**From:** Simon Davis  
**Sent:** 04 January 2019 14:32  
**To:** Planning.Responses  
**Subject:** FW: soakaway pipe work details BE/88/18/DOC

Further Drainage Engineer comments

Scale: 1:100 No. 1891-101 B

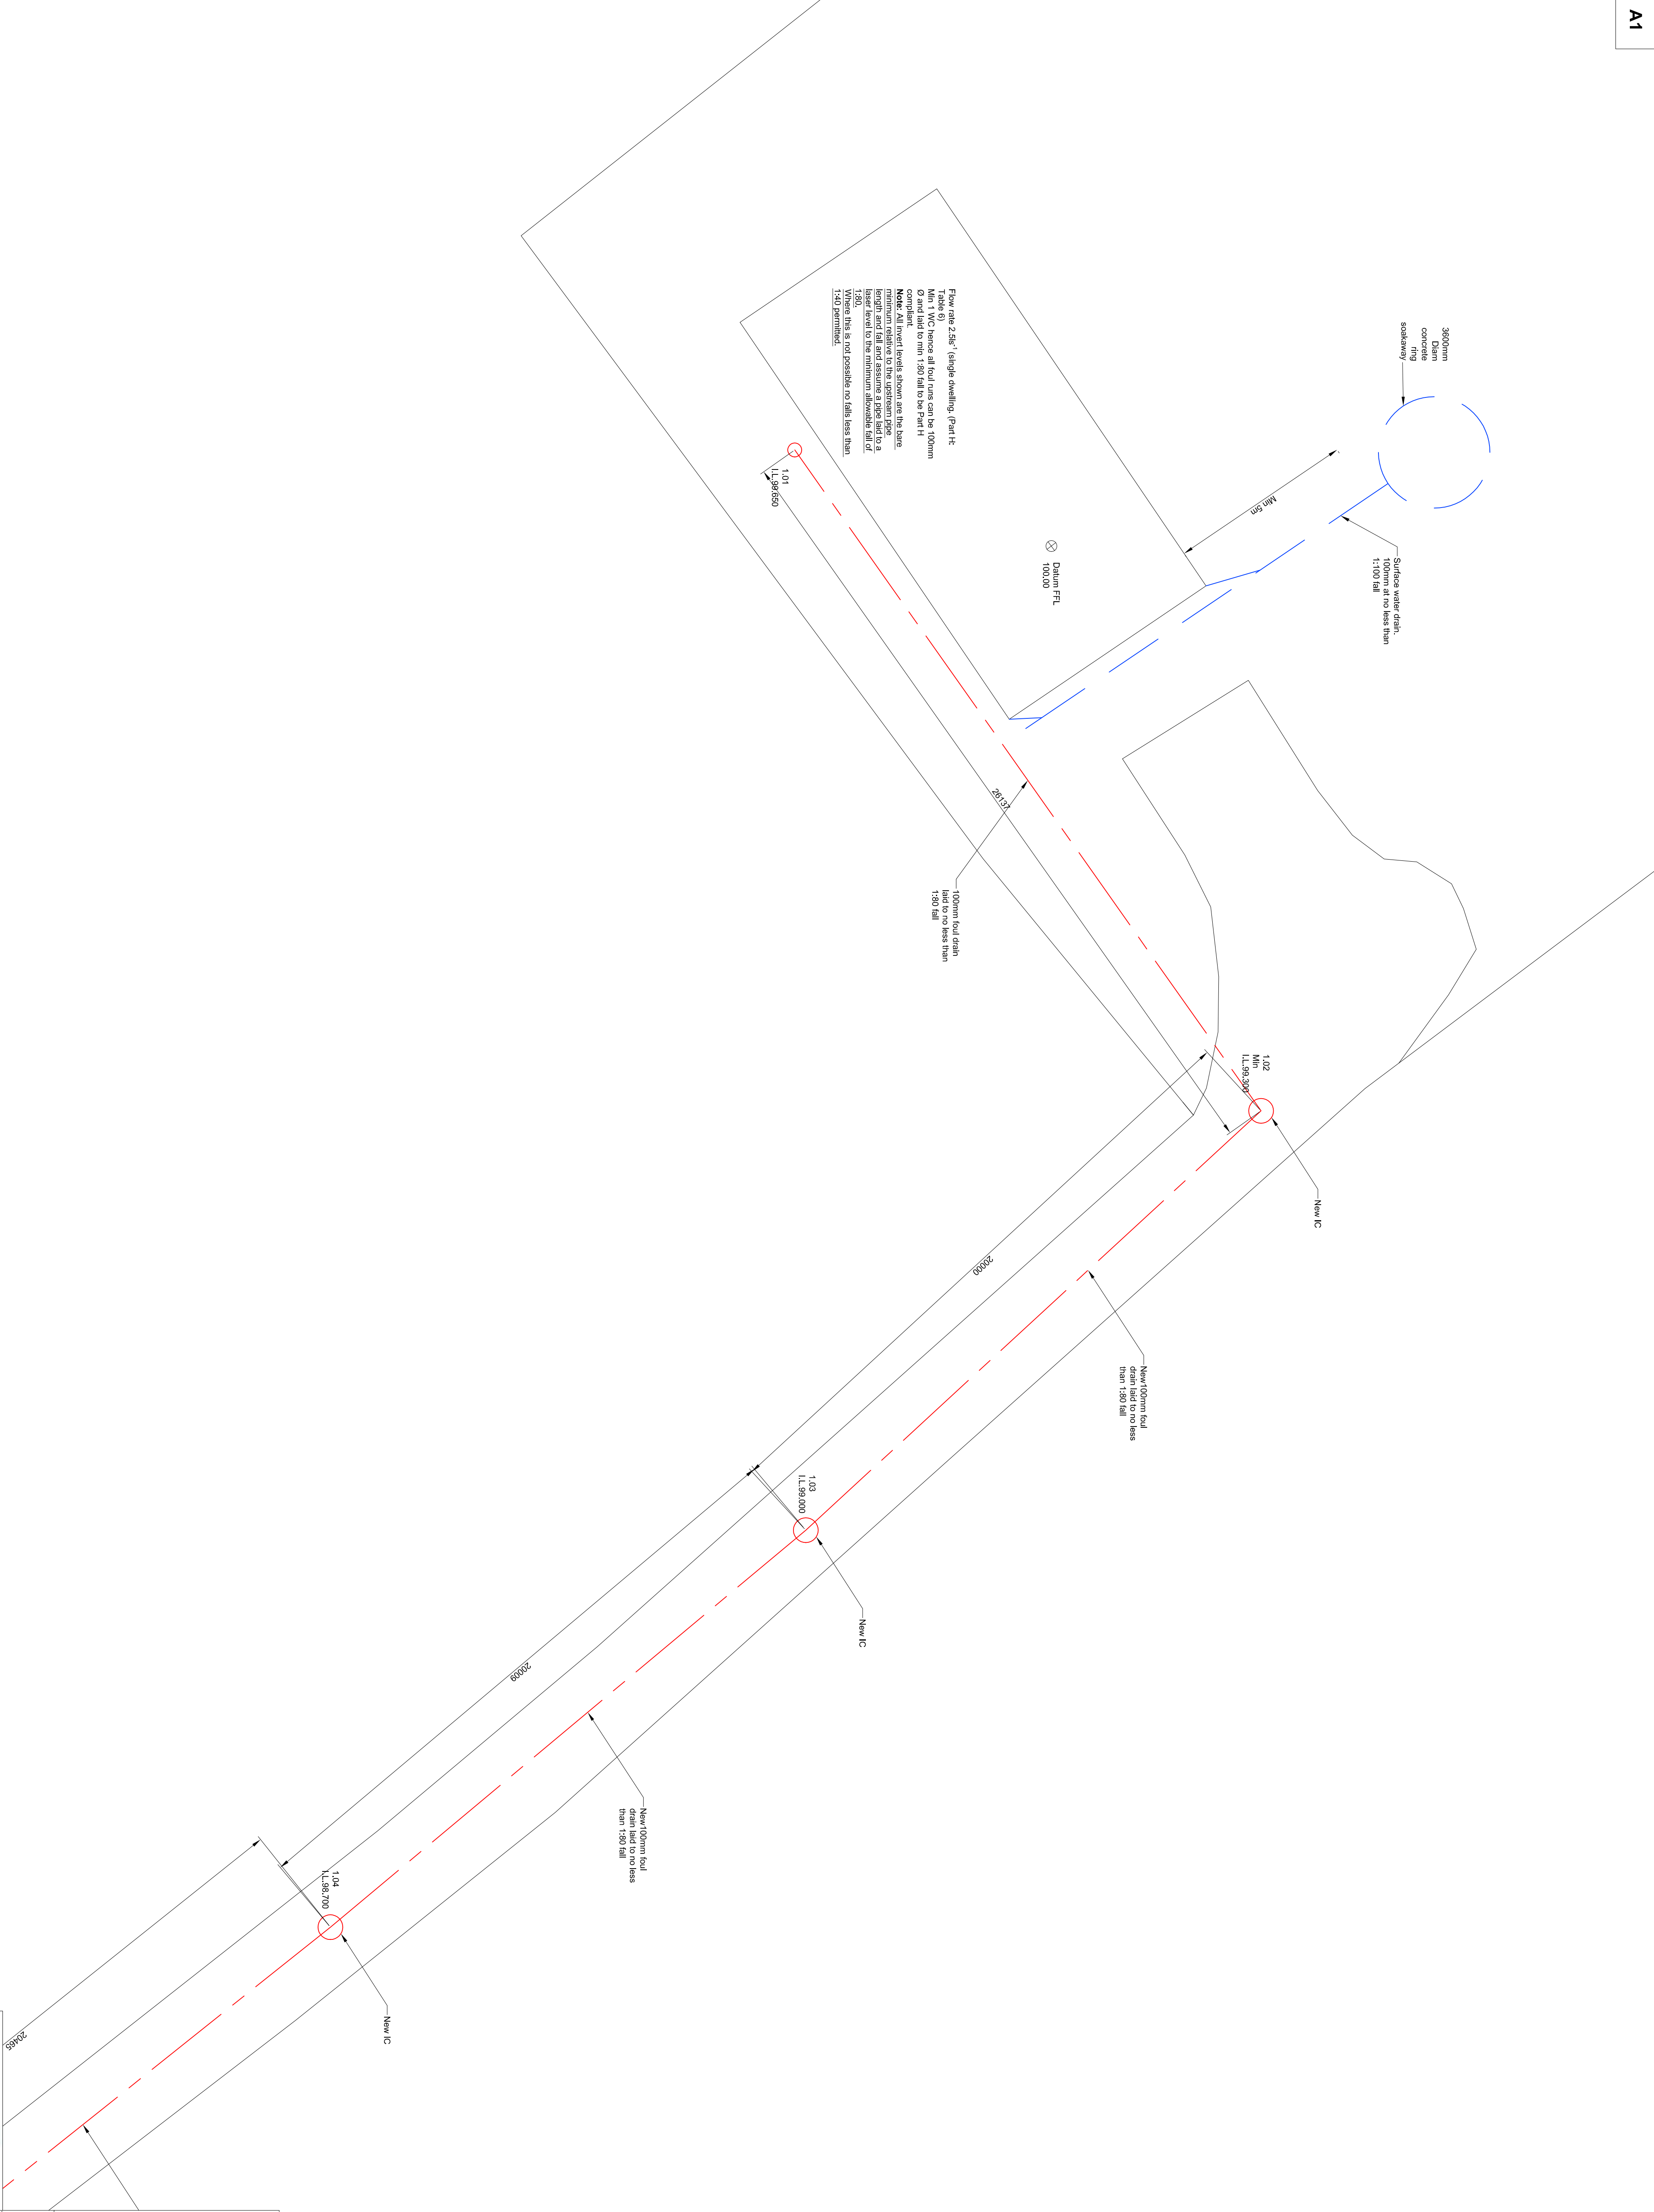
The drawing shows that the pipe bed and surround wouldn't meet our requirements. Please can the applicant ensure 150mm concrete bed and surround is provided. After this, I am happy with the proposals.
